**LAND TO THE EAST OF M40 AND SOUTH OF A4095, CHESTERTON, BICESTER (GREAT WOLF LODGE)
NON-MATERIAL AMENDMENT TO PANNING APPLICATION REFERENCE 21/04158/F**

On behalf of Great Lakes UK Ltd (the 'Applicant') and further to discussions with you on behalf of Cherwell District Council ('CDC'), we are pleased to enclose an application for a non-material amendment ('NMA') to the approved Great Wolf Lodge leisure resort (LPA ref. 21/04158/F).

Proposed Elevations - West

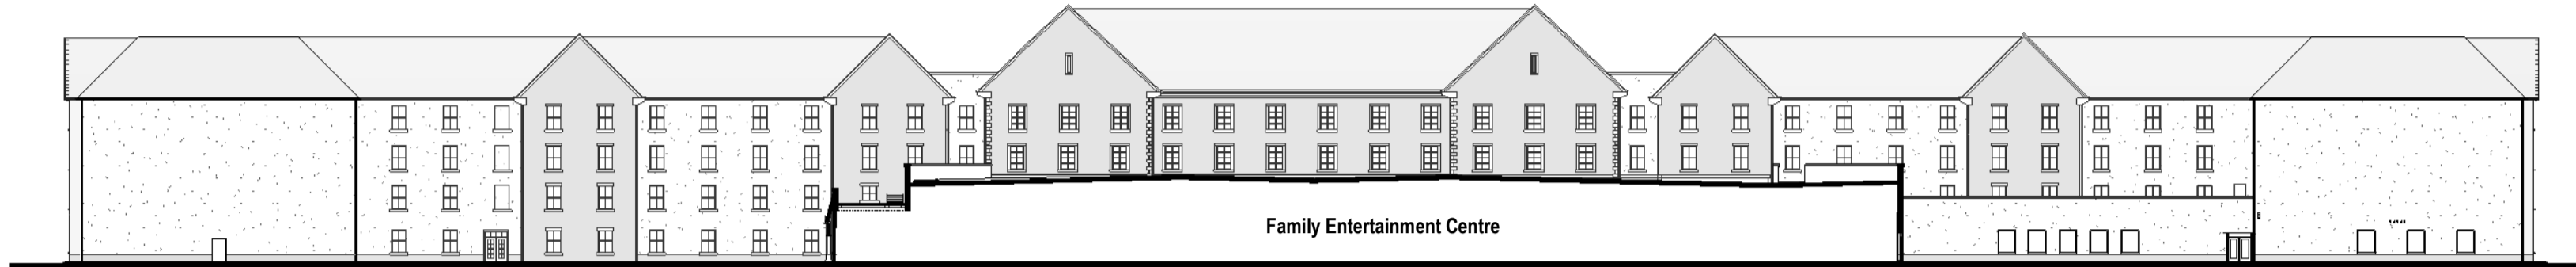
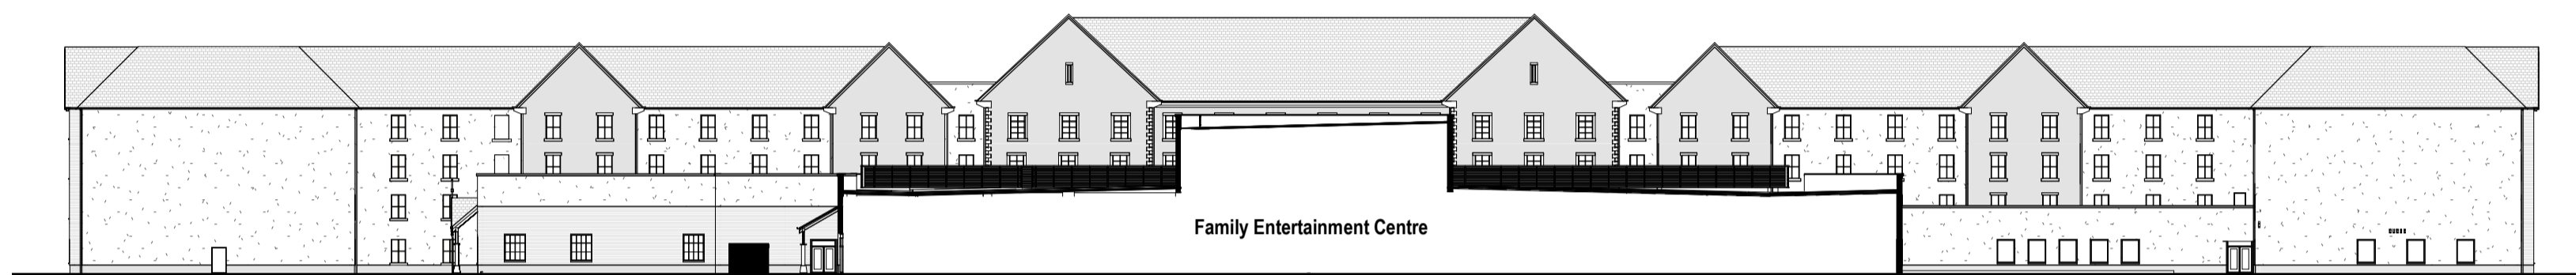
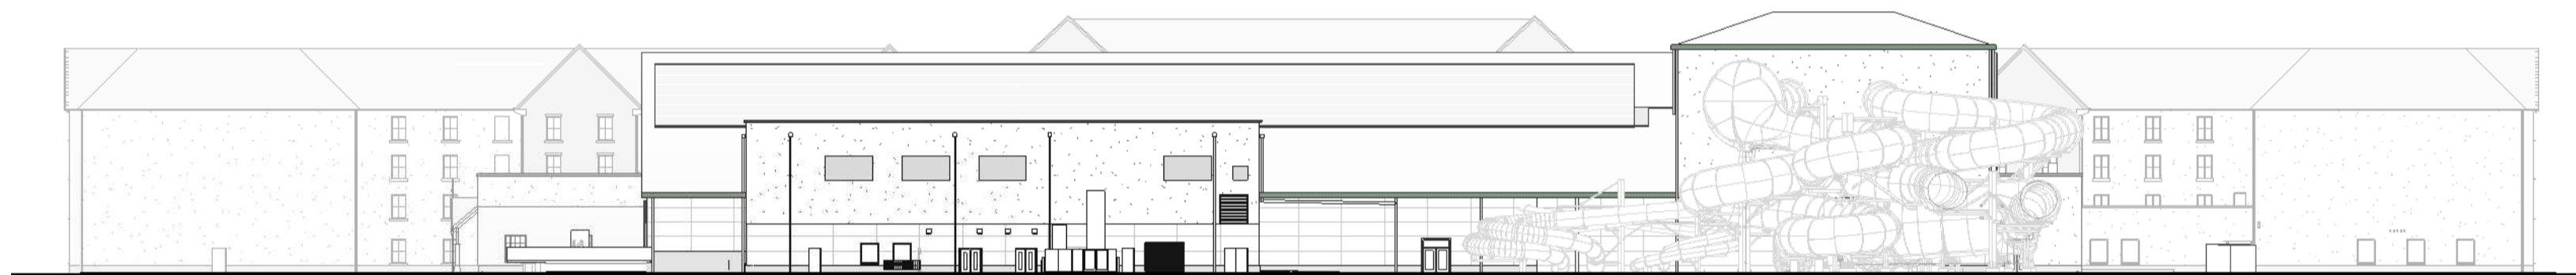
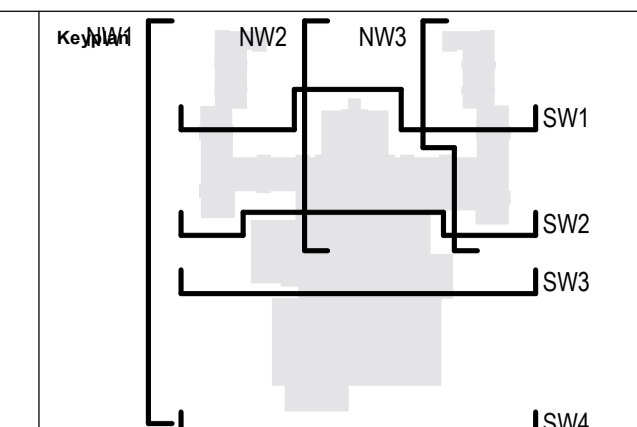
1. Reduction in height to the two flanks of the main hotel building by 654mm.
2. Reduction in height of the central lobby part of the hotel building by 990mm.

3. End facades pushed out on end/corner guestrooms by 52mm.
4. Six additional guestrooms (from 498 to 504) within the consented envelope of the building.

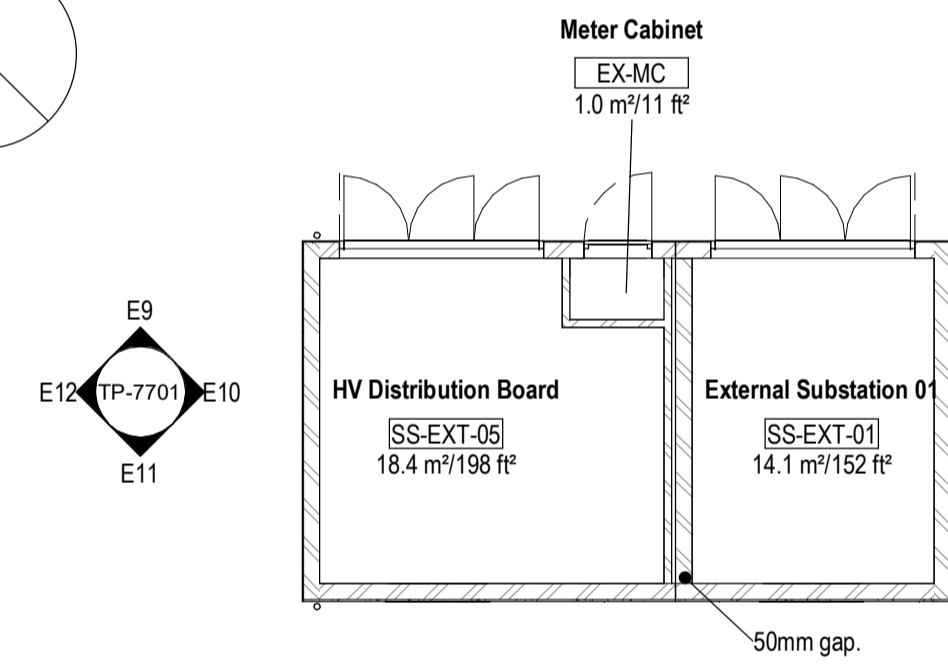
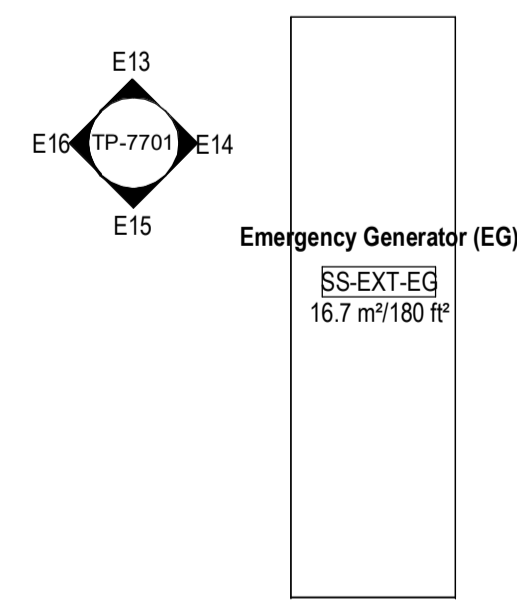
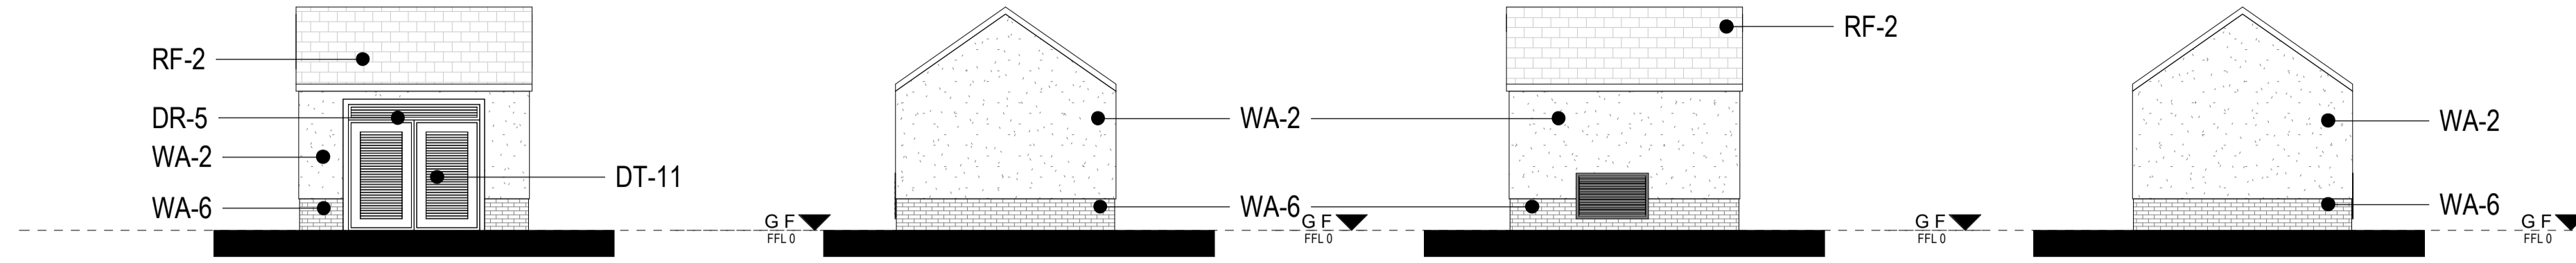
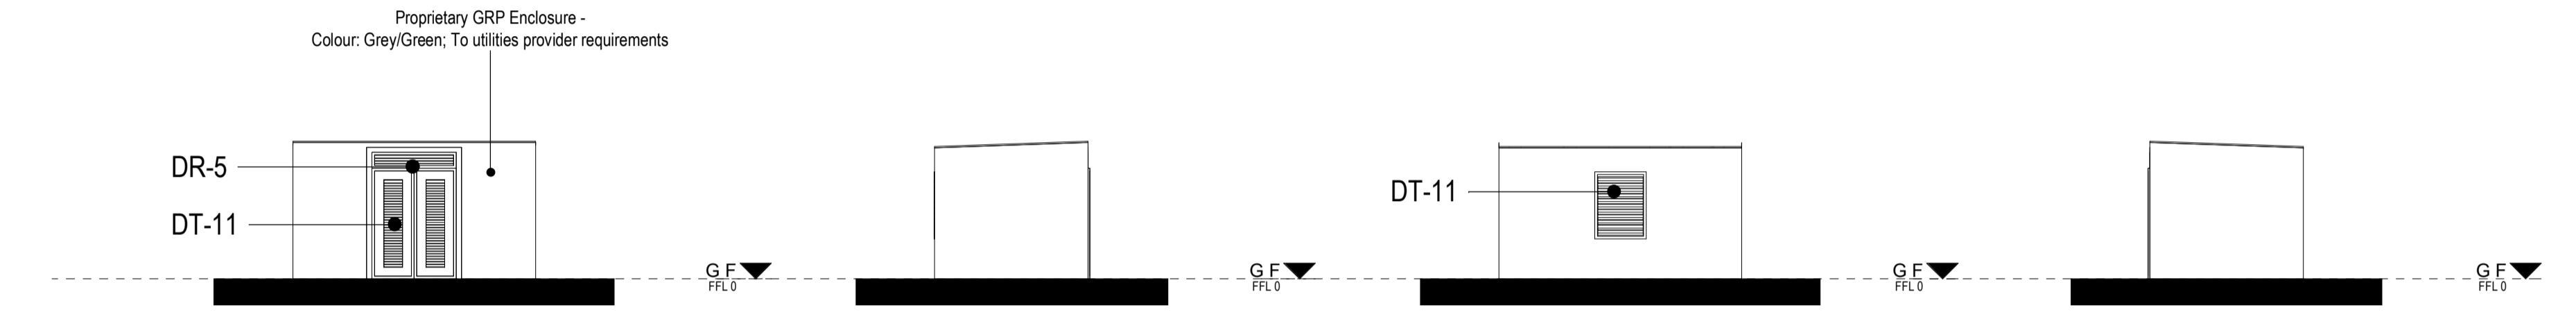
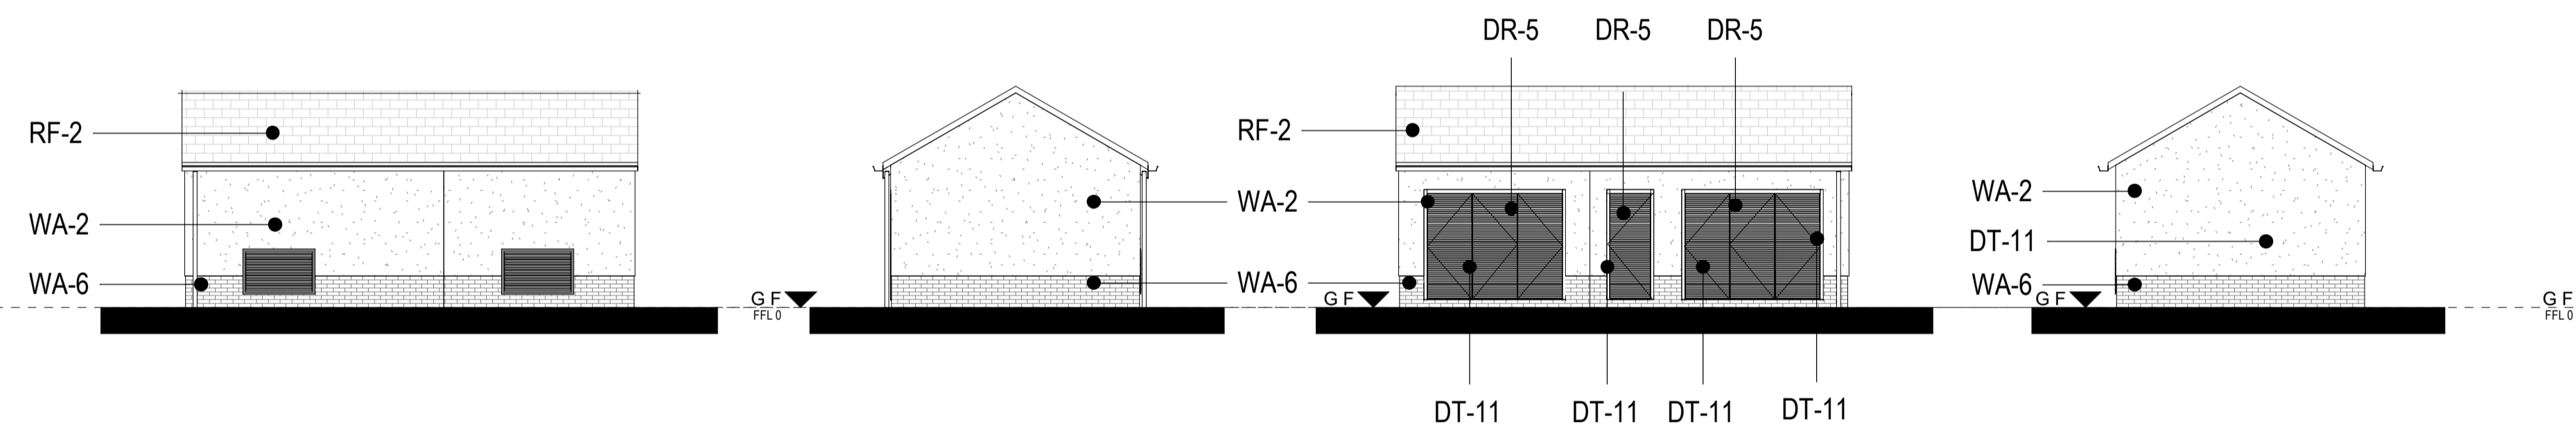
7. Removal of the Substation West (at the northern perimeter of the carpark) and minor alterations to the substations at the southern end of the car park within the landscape.
